KIRKLEES METROPOLITAN COUNCIL INVESTMENT & REGENERATION SERVICE

DELEGATED DECISION TO DETERMINE APPLICATIONS FOR CONSENT, AGREEMENT OR APPROVAL REQUIRED BY CONDITION

Reference No:	2025/44/92088/E
Site Address:	Land off, Bankwood Way, Birstall Retail Park, Birstall, Batley, WF17 9DT
Description:	Discharge of details reserved by conditions 9 (retaining walls) and 18 (Remediation Strategy) on previous permission 2024/91591 for variation of conditions 2-6, 15 and 29 of previous permission 2021/92528 for erection of retail development, associated parking, servicing areas and landscaping
Recommending Officer:	William Simcock

DECISION – Discharge of Condition – Split Decision

Drawing Reference
1080.07 Fig1

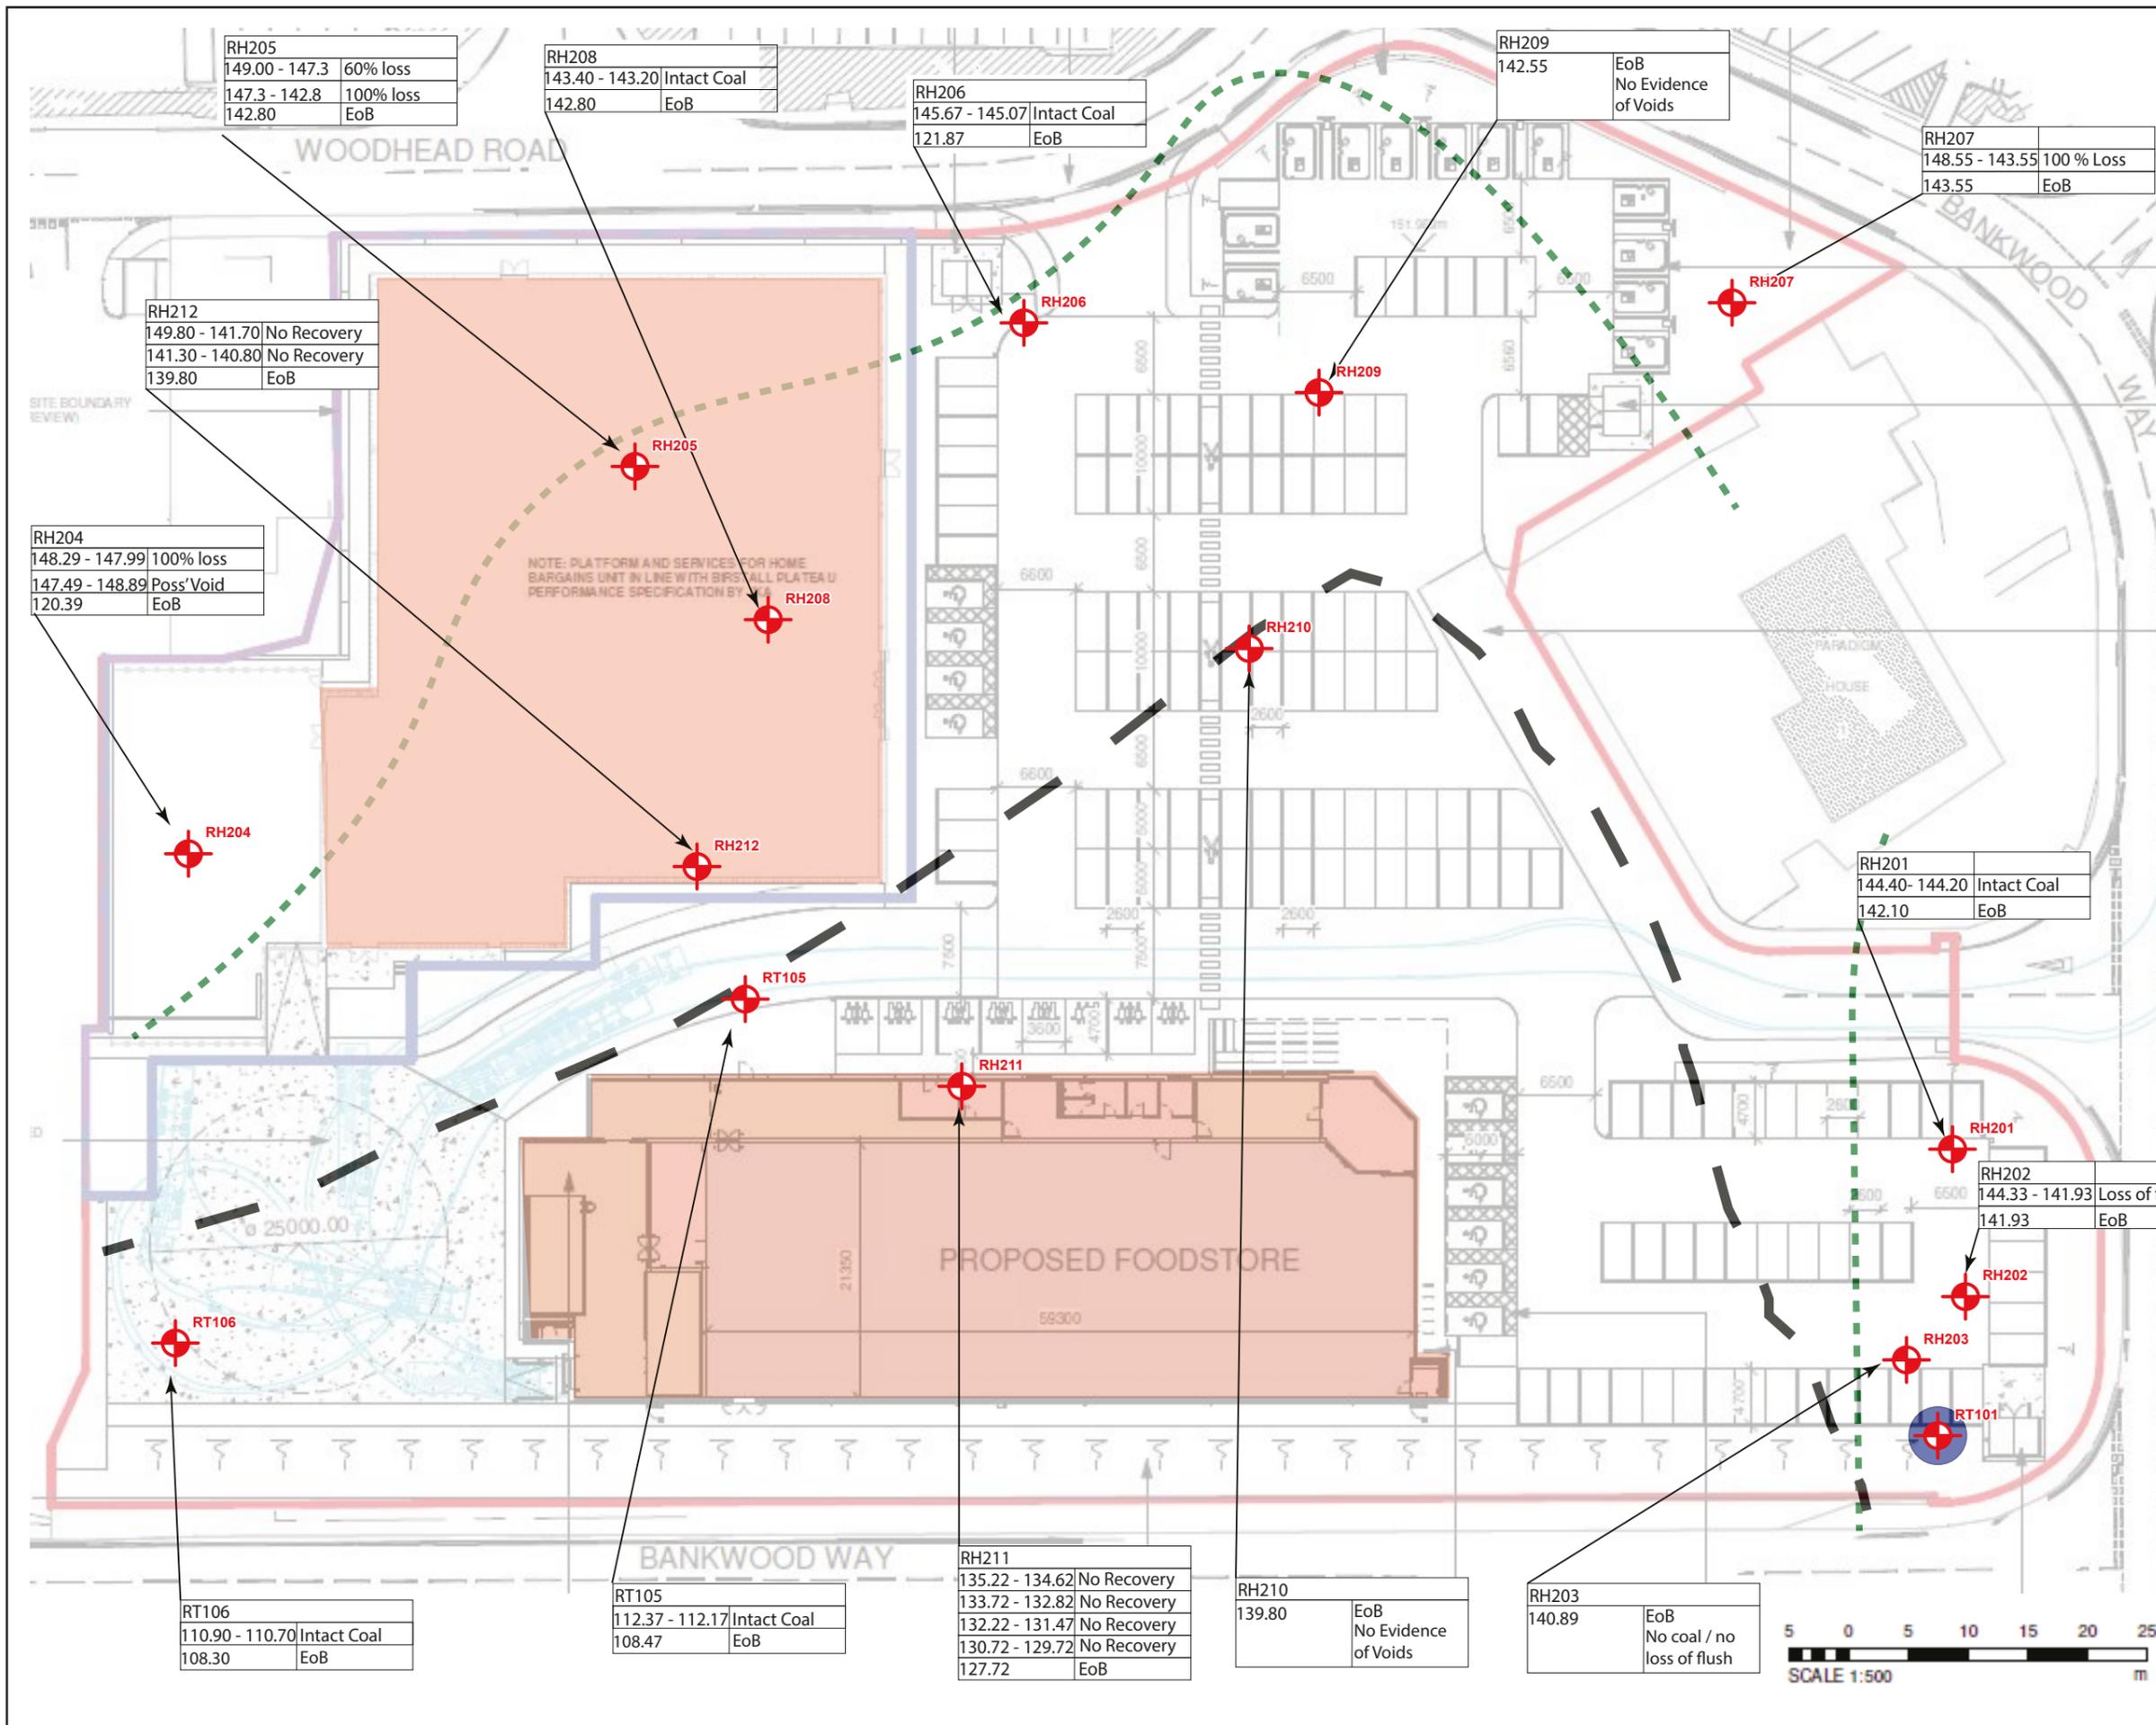
Section 4 of the above report presents the Remediation Outline Method Statement. The section begins by stating that a summary of remediation activities with cognisance to the proposed site layout is shown in Figure 1. Figure 1 is Drawing "1080.07 Fig1", this drawing states that there will be a Site-wide turnover to 1.5m bgl, again contradicting previous information.

Scale:	1:250	Page Size:	A2	Status:	TENDER
Drawn by:	AM	Date:	OCT 2022	Checked:	MM
Project No.:	22254	Drawing No.:	3010	Revision:	T1

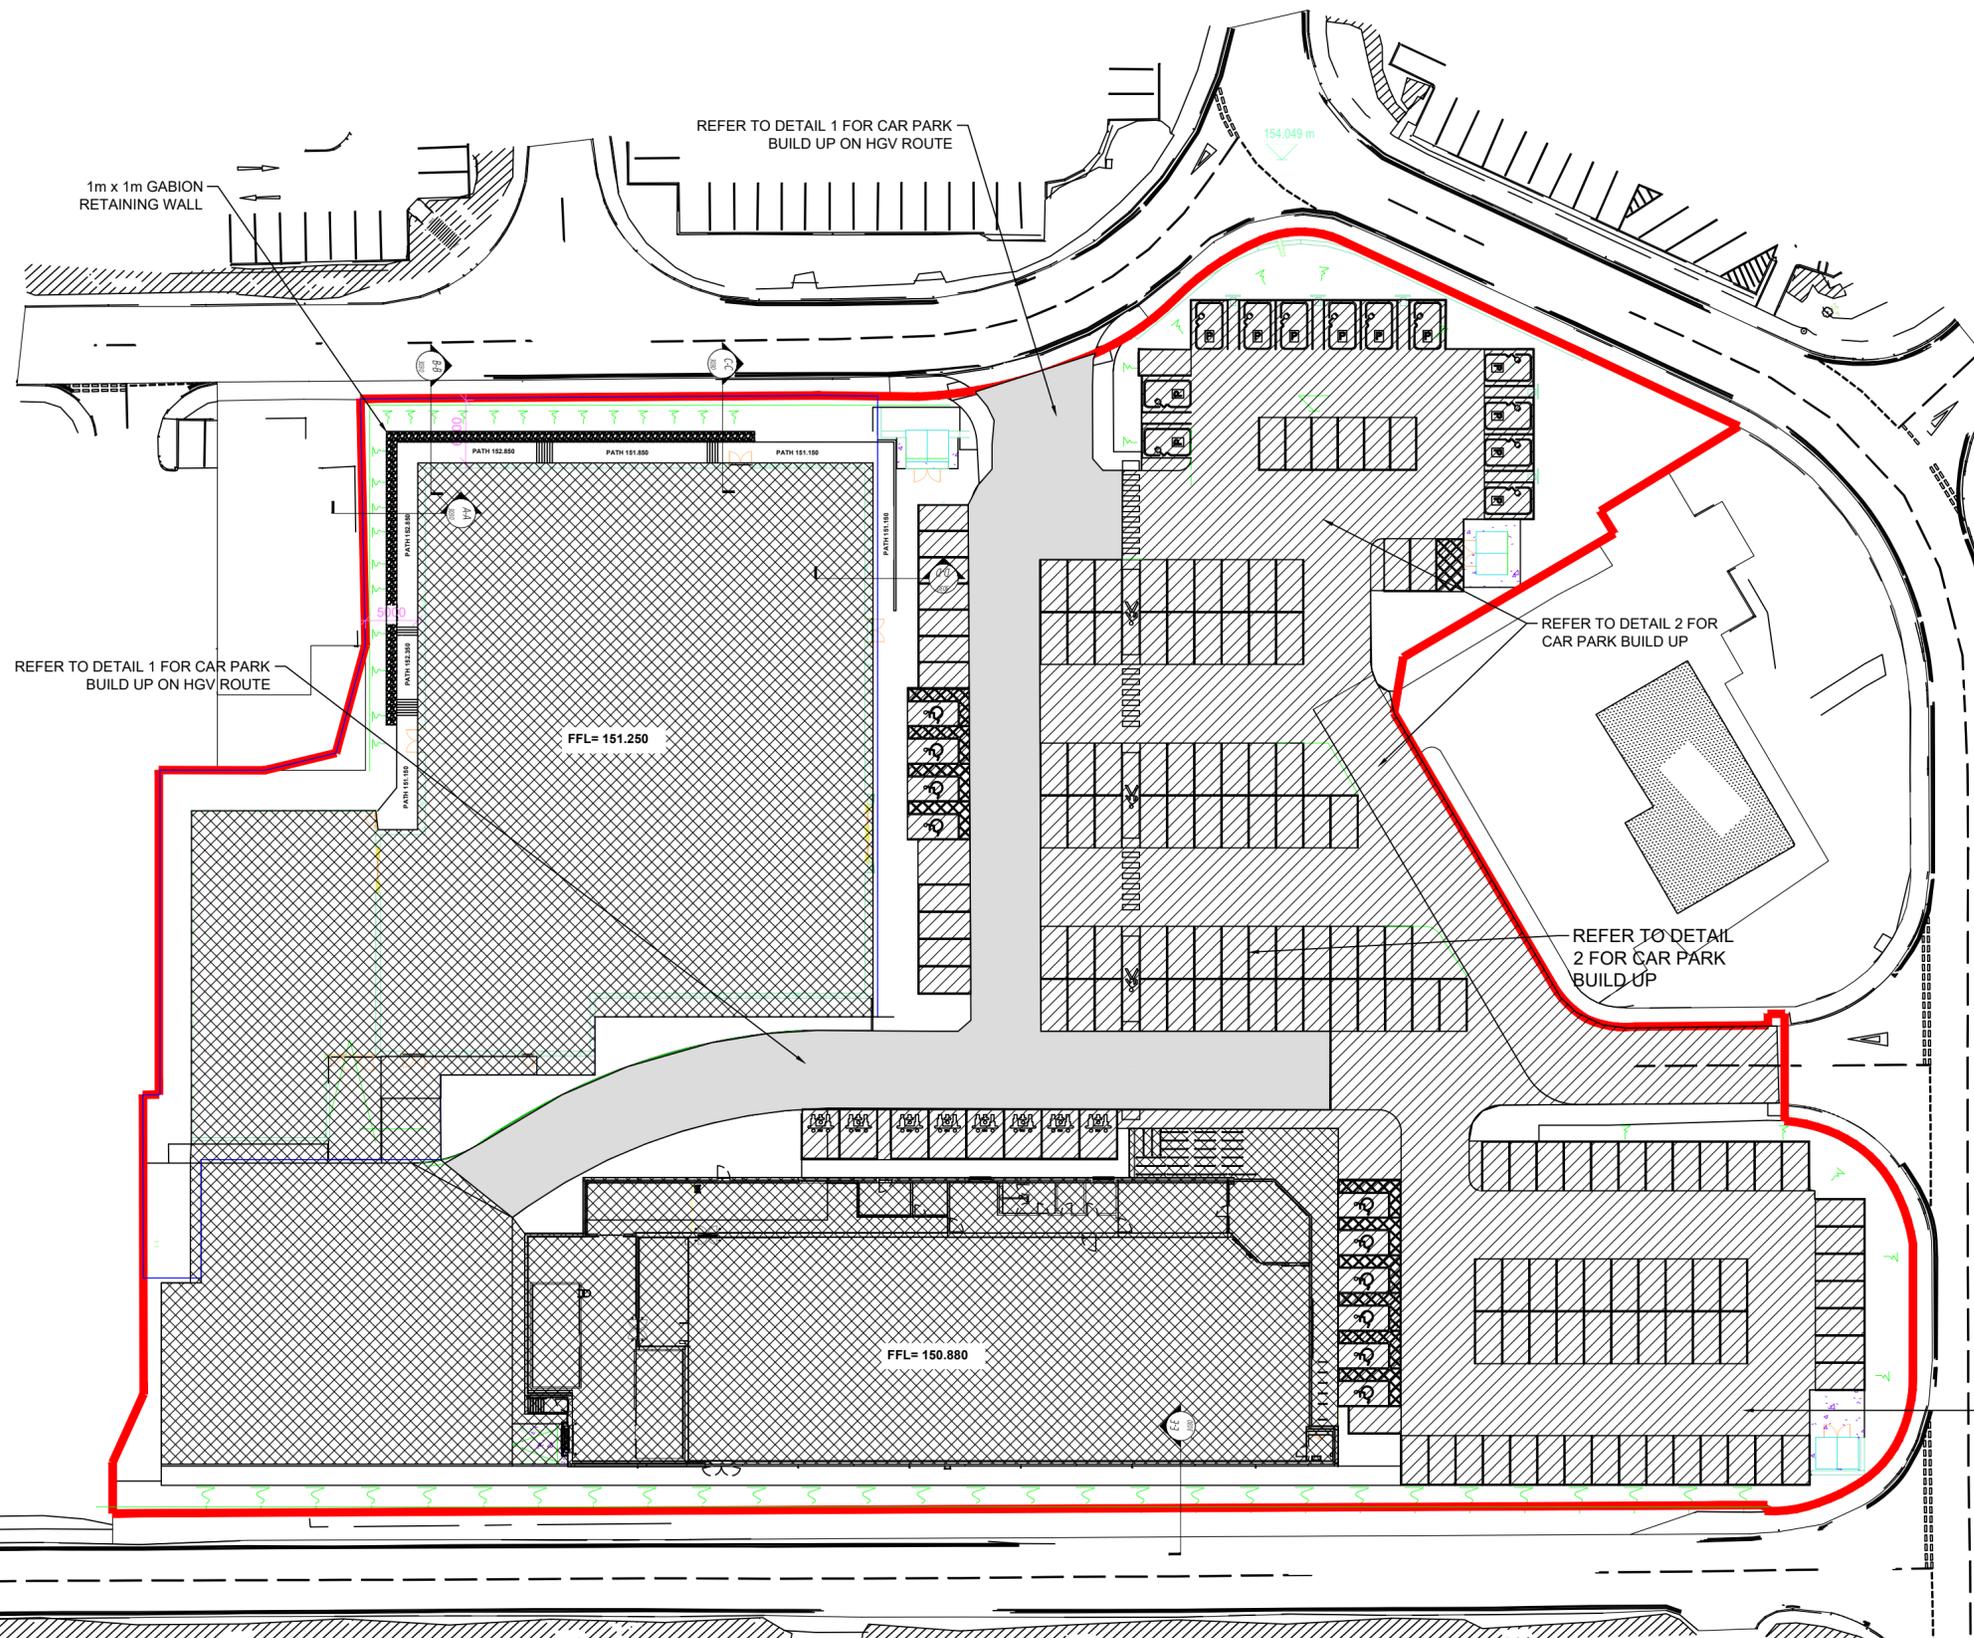
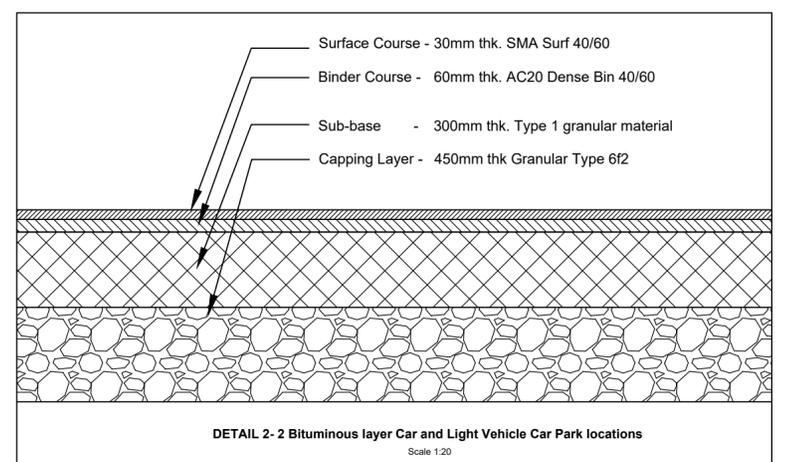
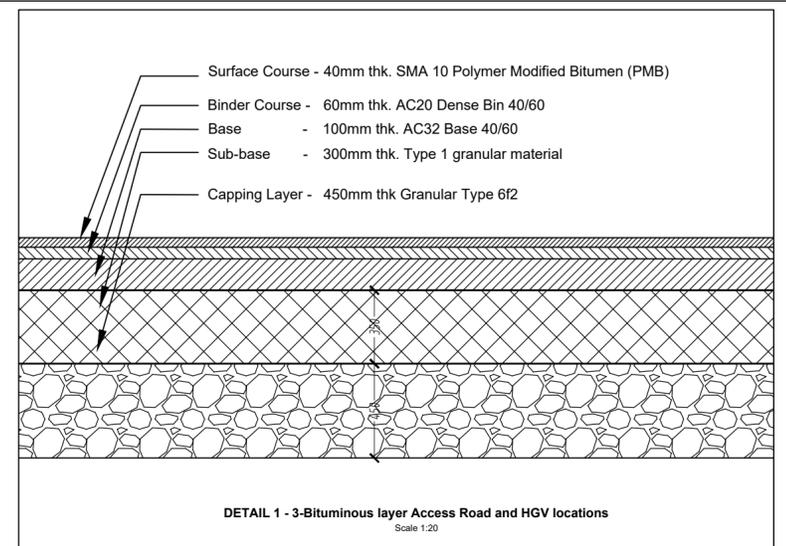
"Ground improvement will be undertaken in accordance with SDS Ground Improvement Plan (drawing ref. 22254-3010-T1, included as Appendix C). The works are summarised below:

- Vibro stone columns underneath building footprints to achieve the minimum bearing capacity specified by the engineer, currently 150kPa; and
- Construction of the capping layer will be undertaken as indicated on the SDS Ground Improvement Plan (Appendix C) as a 450mm layer across the site. The piling mat will be constructed as per the contractor's requirements, which are to be confirmed.
